IP Ref: [REDACTED] 'One Earth Solar Farm'

Re: Serious Concerns regarding a massive BESS proposed on a drinking water protected area

Drawing Title:
OE-ACM-R0-S3-DR-EE-4003
TYPICAL BESS ELEVATION

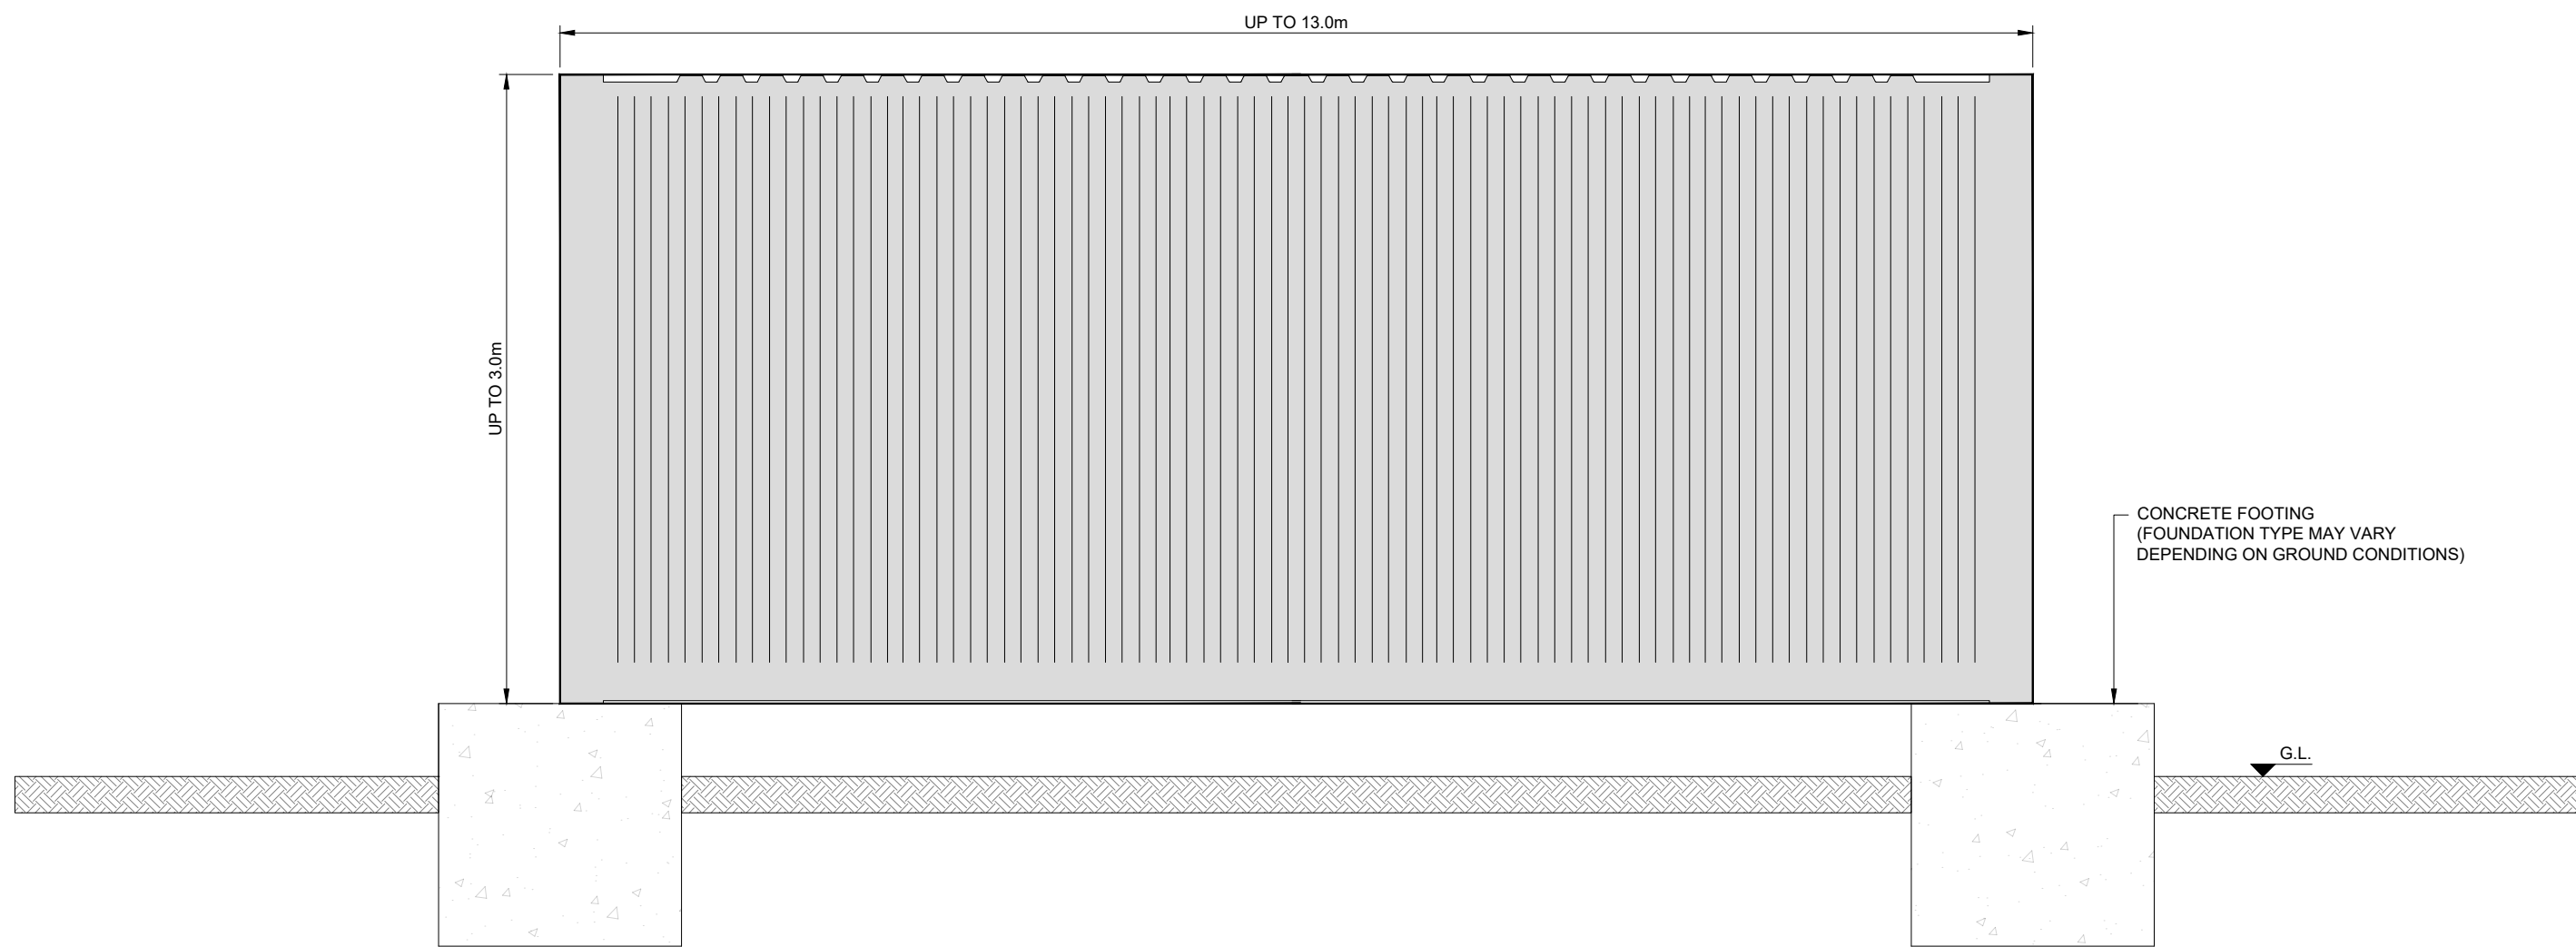
Seemingly four Battery units in one?

When looking at the One Earth plans, we understand that the recommendation is that Battery units should be kept at least 3 metres apart. Consultation documents seem to suggest this is what the plans would be. However, when you look more closely to the plans, it looks like the developers could be counting four separate battery units – separated by just 0.9 metres, as a single unit in itself. We feel – if this is true – that this is also a serious area of concern and again – if true – could demonstrate the developers deliberately ‘playing with words’, and the rule book in the planning application. It also means that there would be no real way for fire services to stop a serious fire from spreading to at least 3 additional containers should one of the 4 fail and catch fire!
